Application Ref: H06-0819-26

Proposal: **Change of use of land to a residential caravan site comprising 4 Gypsy/Traveller pitches, each accommodating a static caravan/mobile home and a touring caravan, together with hardstanding, erection of 4 amenity buildings and improvement of existing access - retrospective**

Location: **Land south of Blazegate and West of Gedney Drain, Gedney, Spalding**

Deferral: LCC is not currently in a position to support the application and requests further assessment, supporting evidence, revisions and/or dialogue, as set out in the response.

SITE LAYOUT PLAN

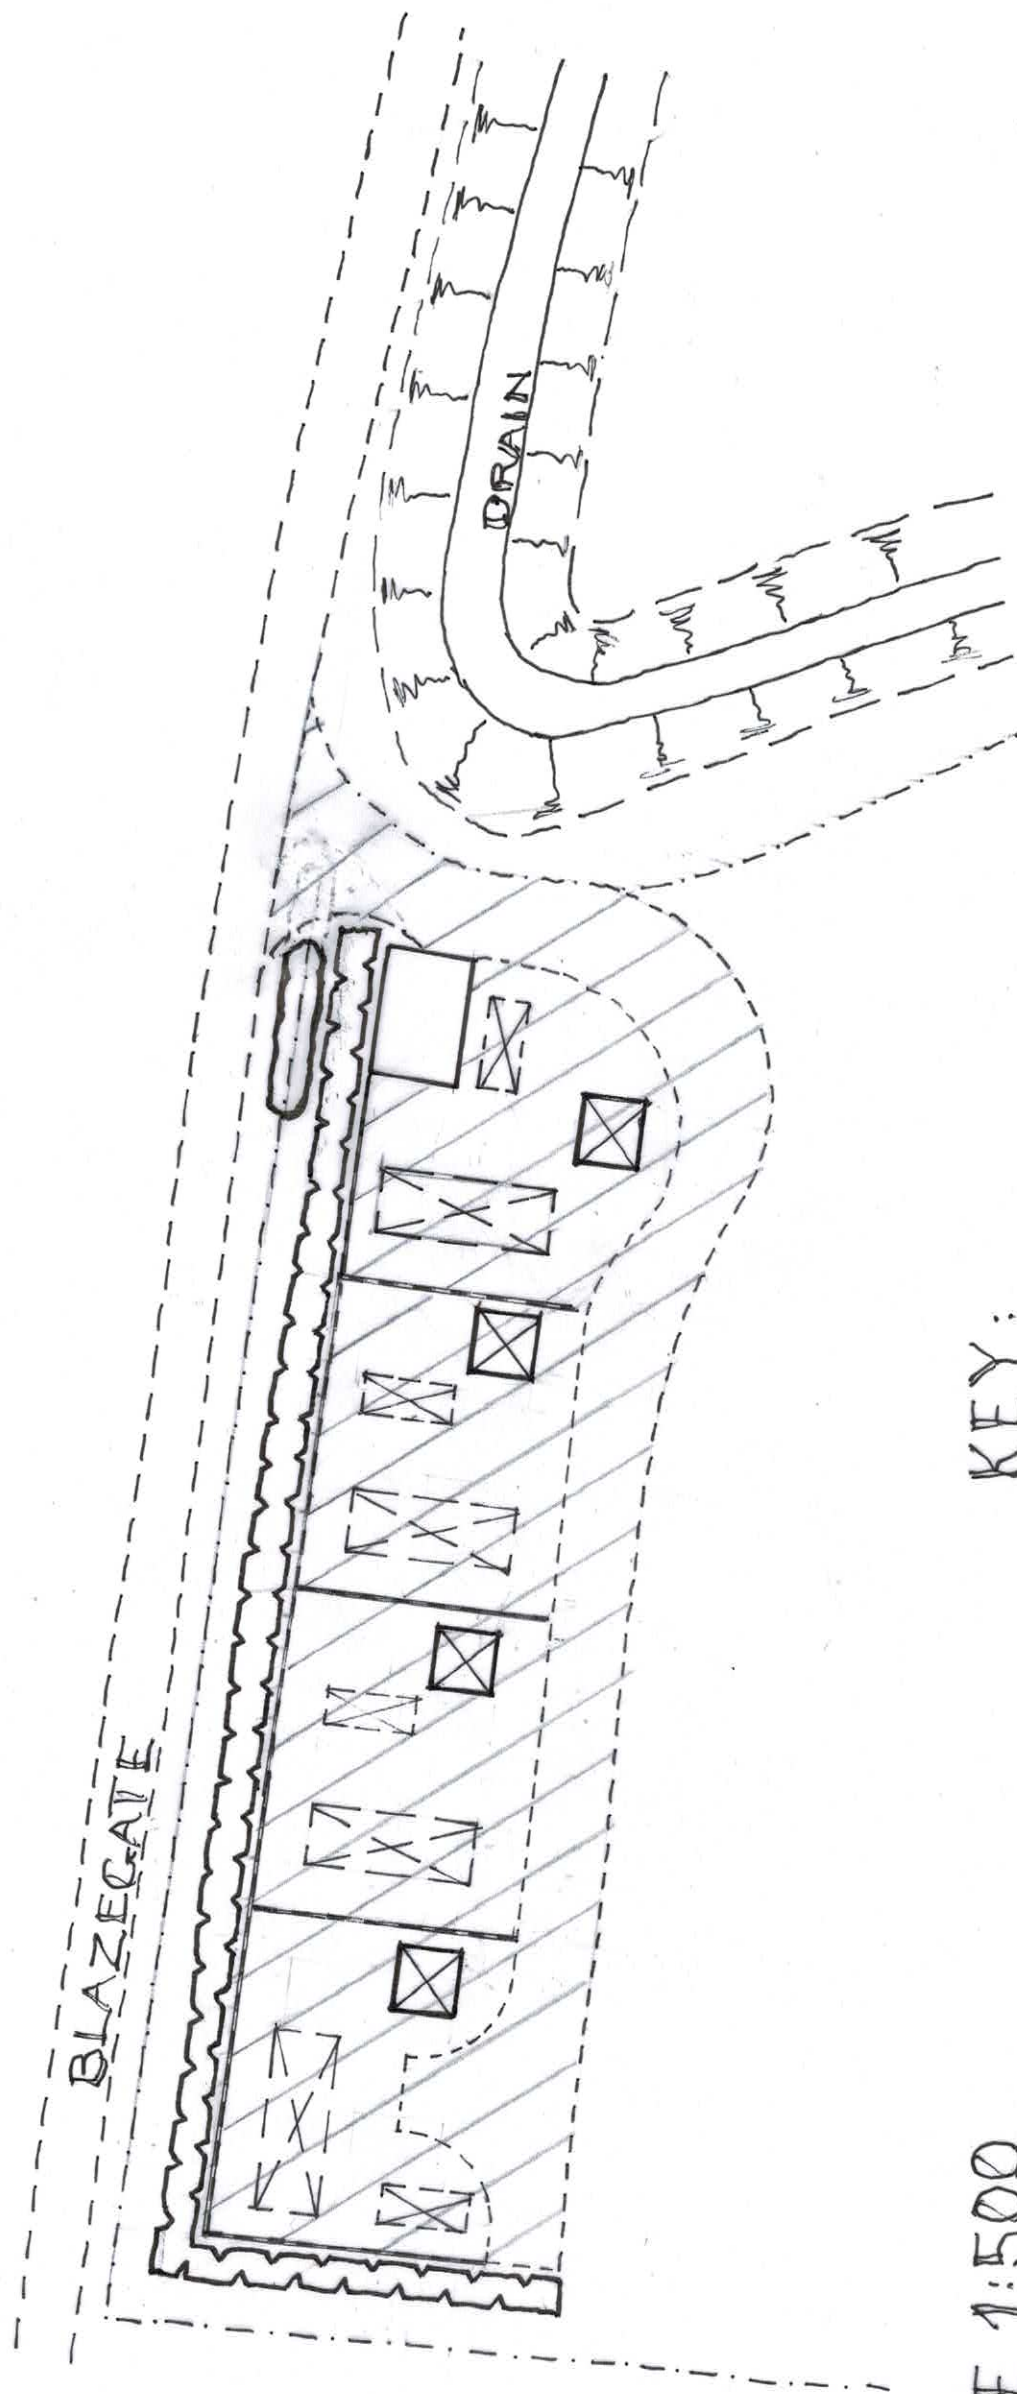
The Local Highway Authority has reviewed the submitted information and notes that the proposal would utilise and improve an existing access onto Blazegate. Whilst no in-principle highway safety or capacity concerns are identified at this stage, additional information is required before a final recommendation can be provided.

The applicant is requested to update the access/site layout drawing to:

- show the maximum achievable visibility splays from the access in both directions; and
- include a note confirming that the access improvements shall be constructed to current LCC specification under a S184 agreement

This information is required so that the visibility splay and construction can form part of the approved plans, should planning permission be granted, and to ensure the extent of any future visibility maintenance requirements is clearly defined. The final design and construction details of the access would remain subject to approval under the Section 184 process.
